Department of Planning and Environment

Our ref: DOC22/612181

Your Ref: SSD-33781208

Subject: Request for Advice - Station Road Data Centre Expansion, 57 Station Street Road, Seven Hills (SSD-33781208)

Figure B2 : NSW202013_DA-C3.001[D]_Civil Works Plan Approved under DA-21-01058

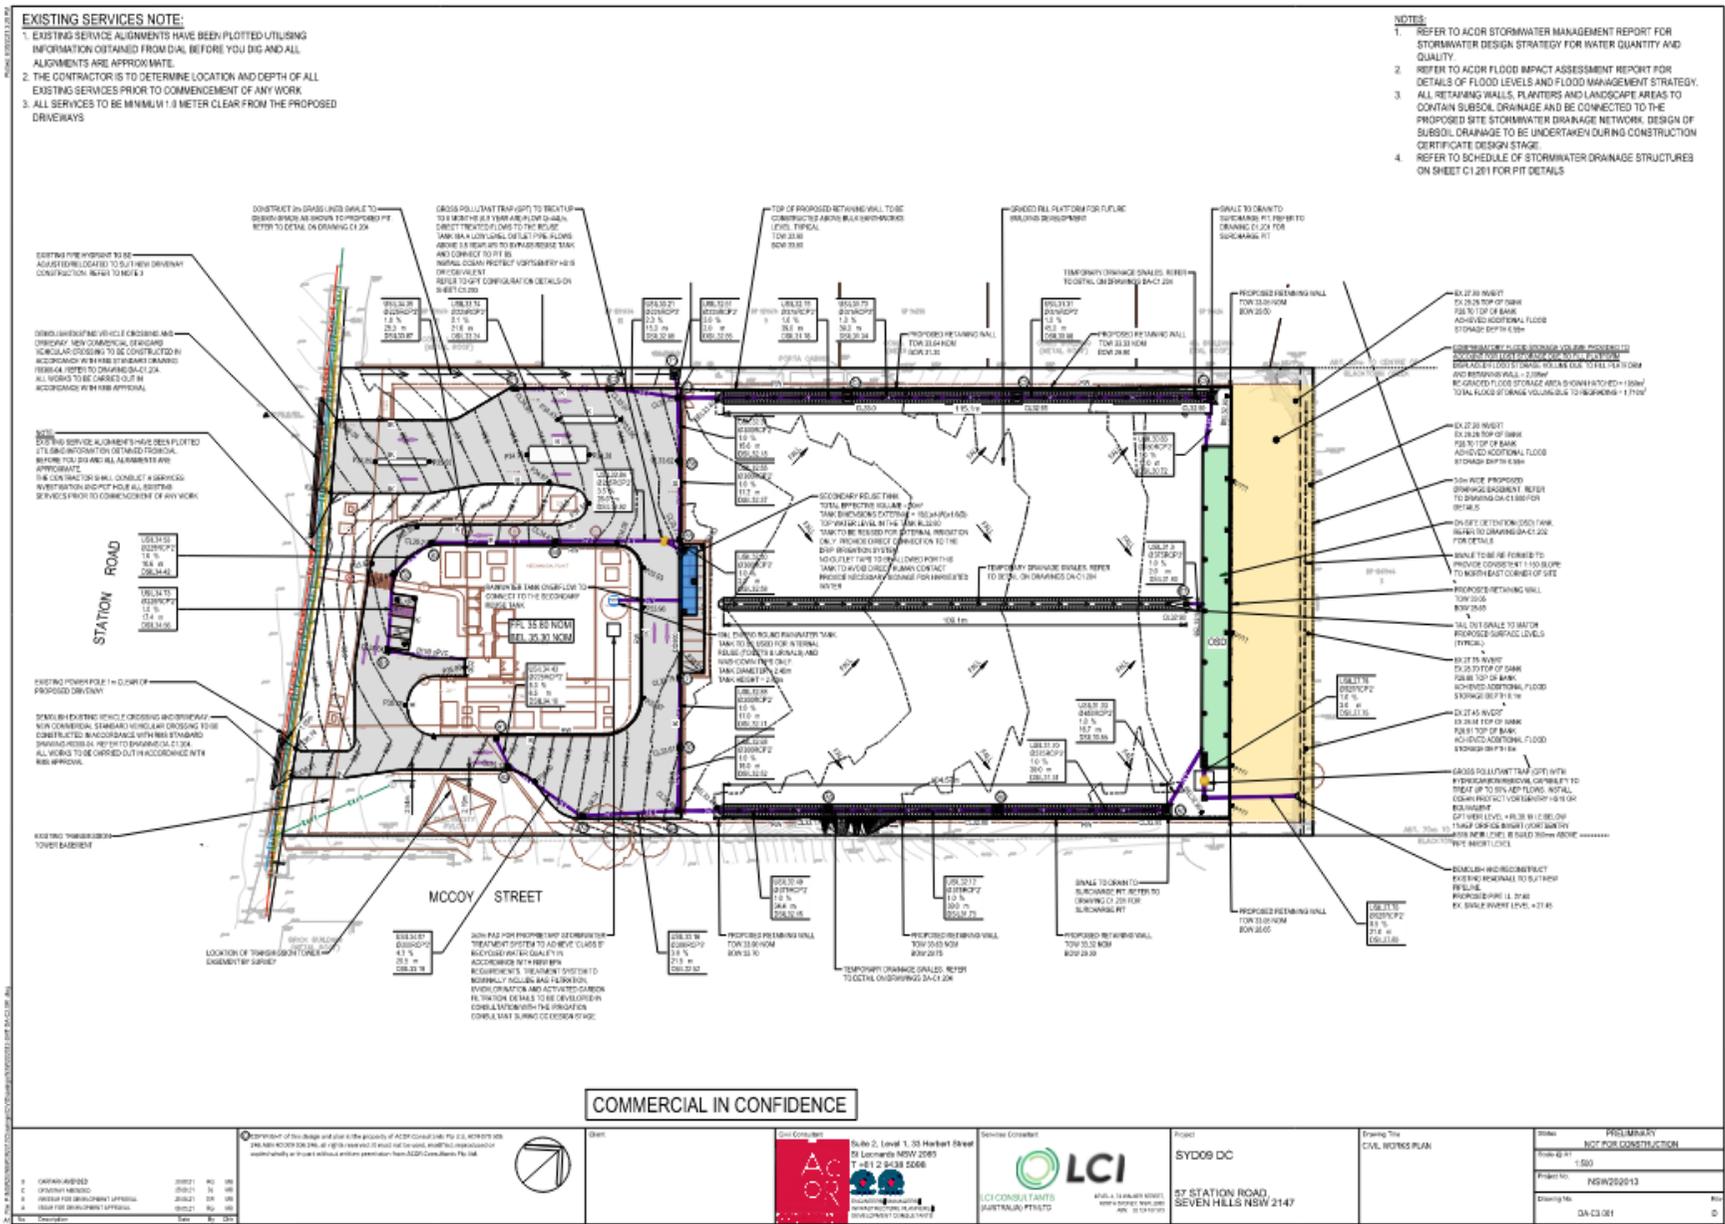
EHG notes that aerial photography of the site shows several mature trees along the north eastern boundary of the property. Tree protection zones are likely to extend into the property given the size and maturity of the trees. While the EIS (Figure 11) shows only minimal cut and fill to occur along the north eastern boundary under the DA-21-01058 consent, the EIS identifies that the proposed level of cut and fill on the site will vary from the works approved under the previous consent.

It remains unclear from the EIS the extent, if any, of additional cut/fill is proposed in this area, and what impact this may have on trees that have not been approved for removal under the previous consent or considered as part of the current application. The applicant is required to clarify the differences between the consent for DA-21-01058 to the current proposal in this area along the north eastern boundary. Specifically, in relation to civil works including cut/fill, stormwater works and fencing, all of which can have an impact to neighbouring trees.
